You application above for works at 7 Follet Close has received comments from our tree officer. Currently the work which you have proposed is for refusal.

TPO/AW/228/10

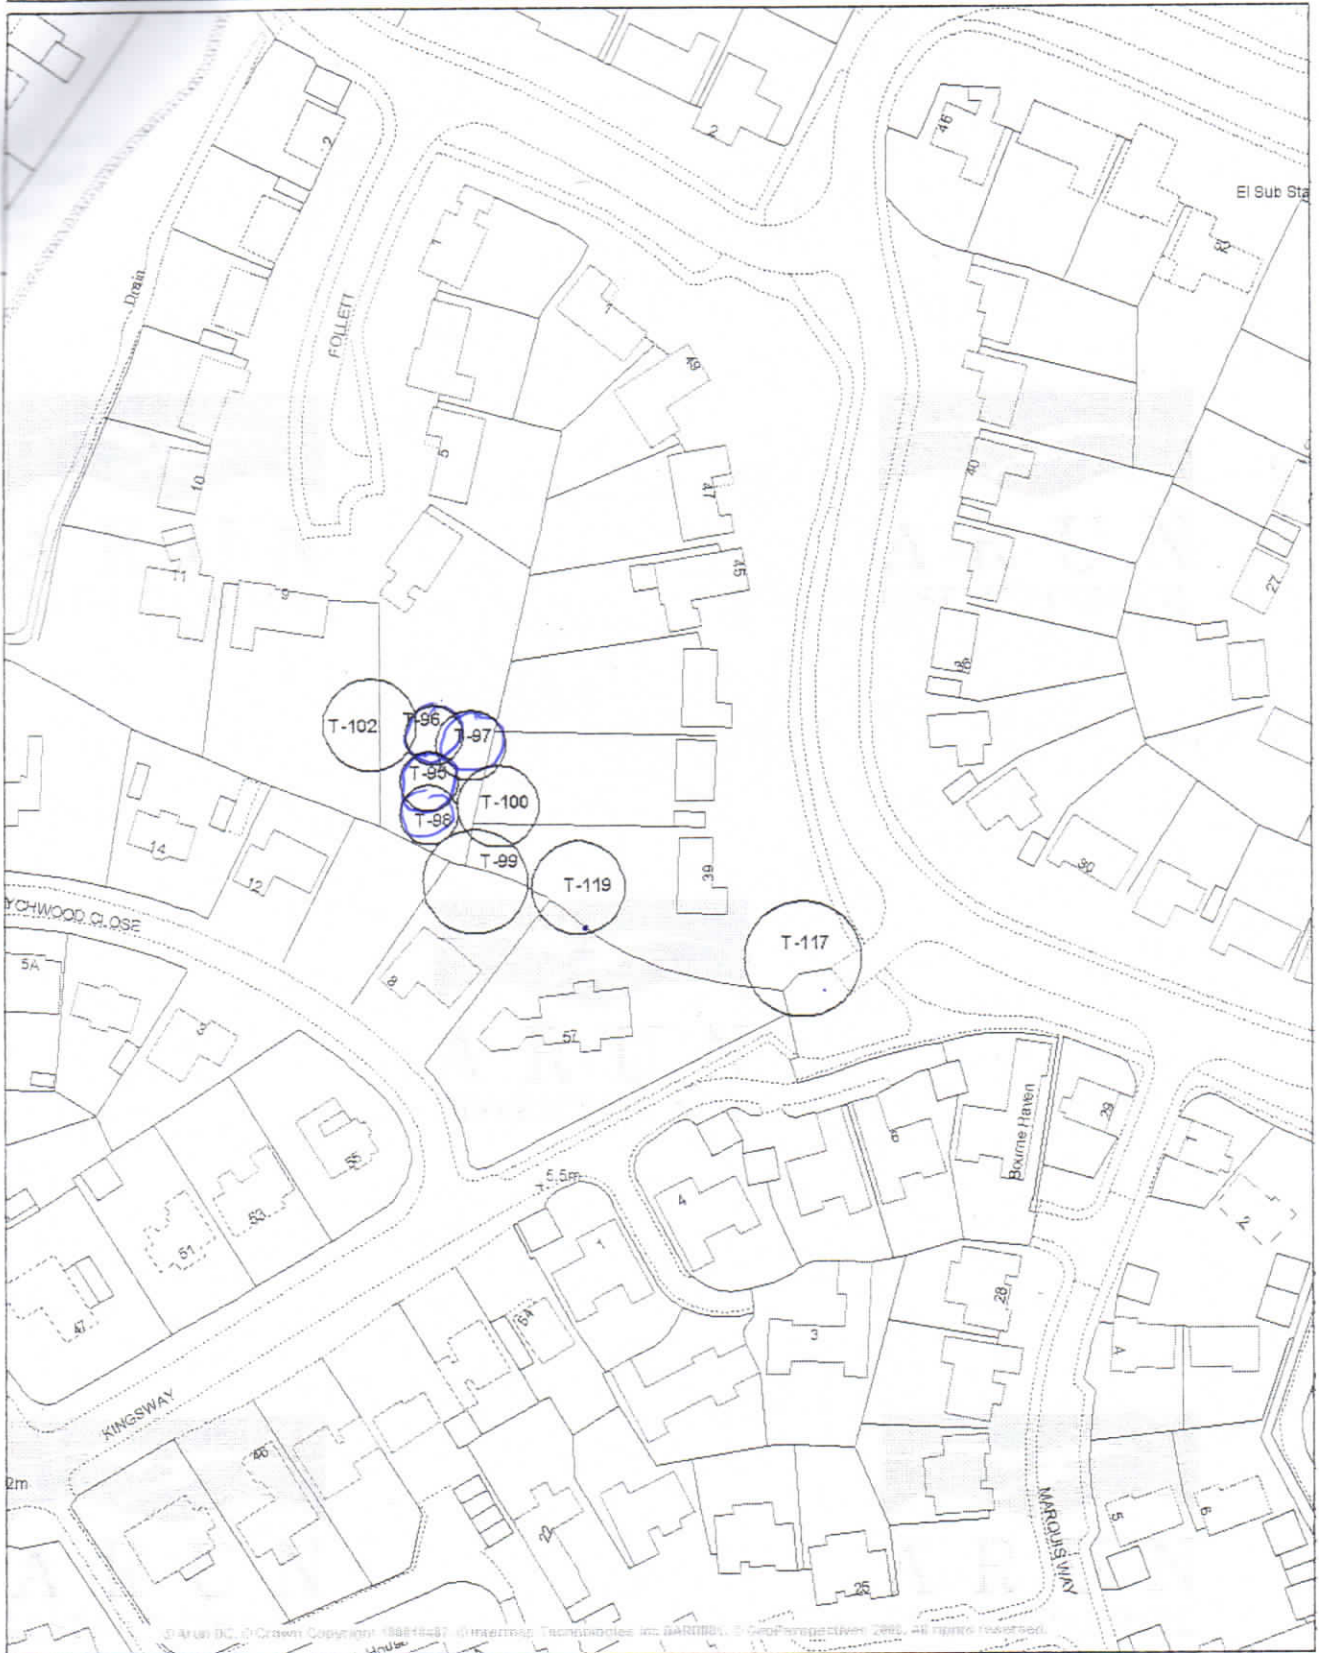
However, our tree officer has outlined a proposal of T95, T96, T97 & T98 for Crown lift (removal/reduction of low branches) to achieve no more than 3metres overhead clearance on all aspects. T95 & T98 only reduce top-height only to leave a minimum of 12metres above ground level.

We are pleased to accept the recommendation that have been made and please proceed with our application.
